Environmental Health Division  
1675 W. Garden of the Gods Road  
Suite 2044  
Colorado Springs, CO 80907  
(719) 578-3199 *phone*  
(719) 578-3188 *fax*  
[www.elpasocountyhealth.org](http://www.elpasocountyhealth.org)

**11955 Falcon Hwy Event Center, VA-20-3**

Please accept the following comments from El Paso County Public Health for the variance request referenced above:

STILL WATERS RANCH
 OWTS PLAN FOR:
 1965 FALCON HIGHWAY
 EL PASO COUNTY, COLORADO

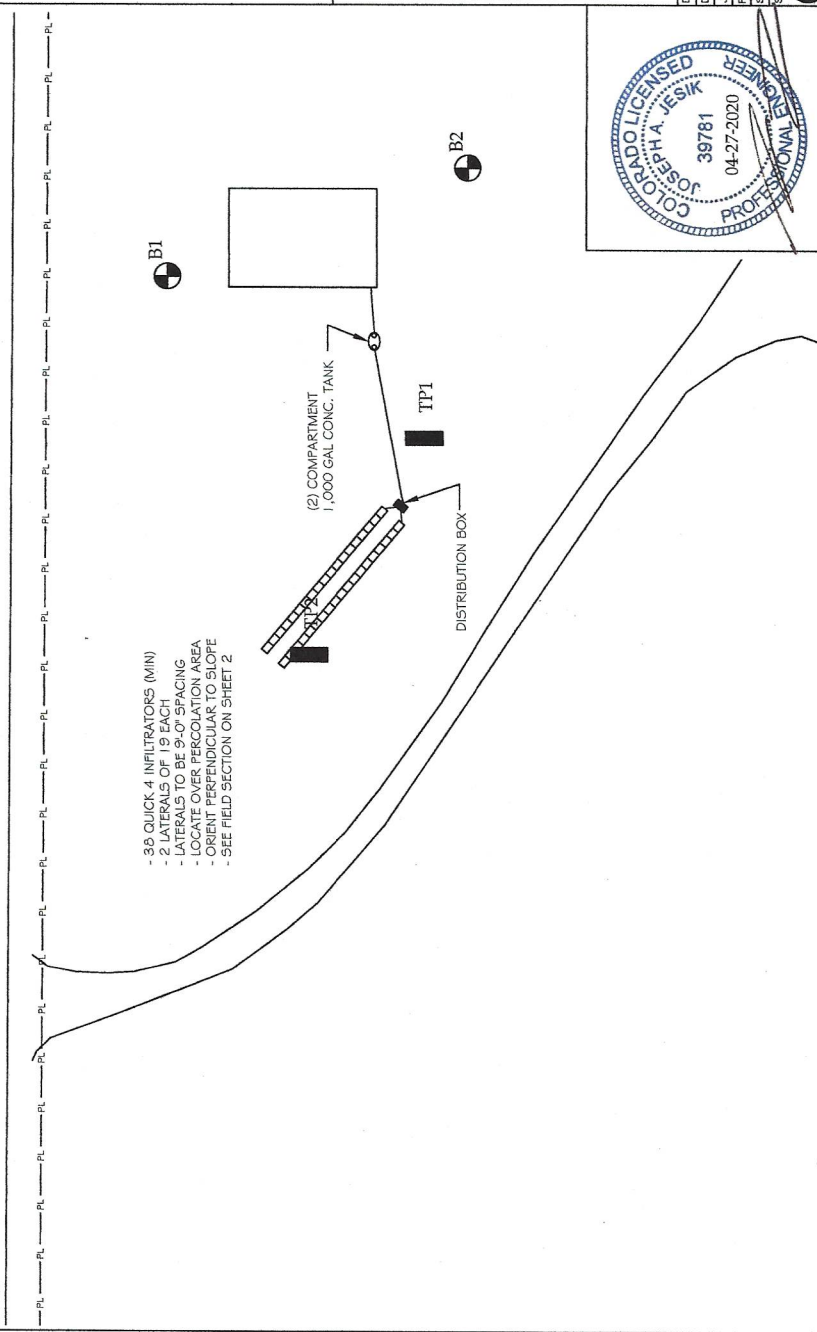
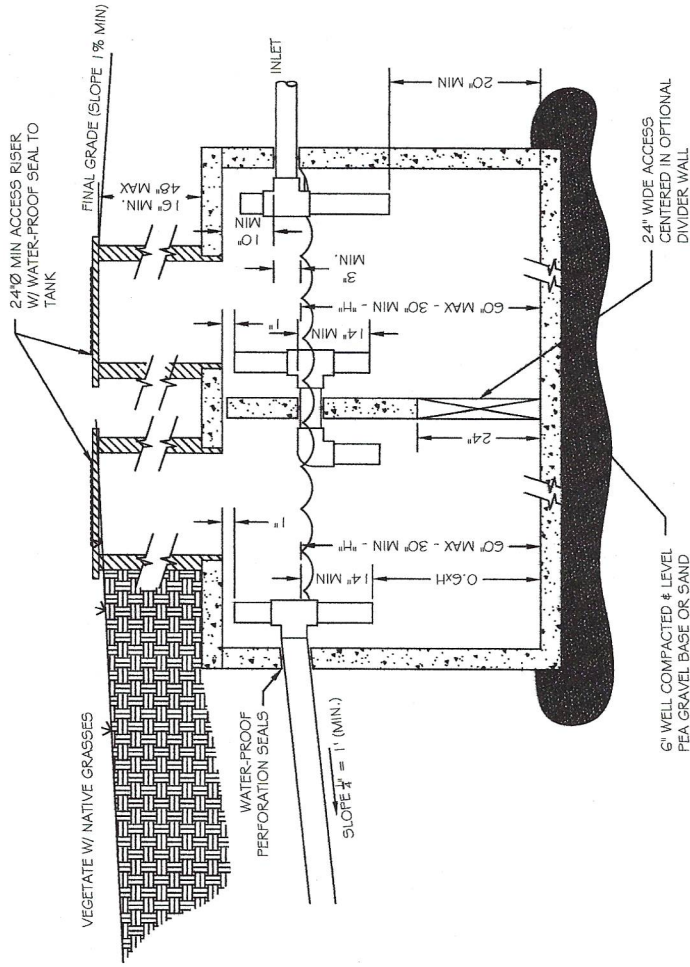
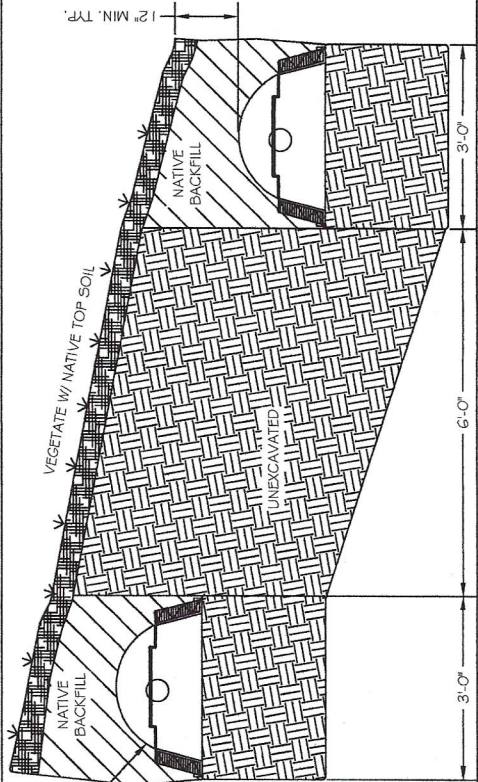
- **Wastewater service for the proposed event center is by a new onsite wastewater treatment system (OWTS) and must be designed by a Colorado Registered Professional Engineer. The Jesik Consulting OWTS design dated 27April2020 was reviewed. The calculated design is for 4.8 gallons/person/day for a total of 360 gallons/day. The per person wastewater rate was based upon flows for an Assembly Hall. Documentation is needed to support the daily per person flow rate for a facility with 75 people maximum per event where alcohol and food are served.**
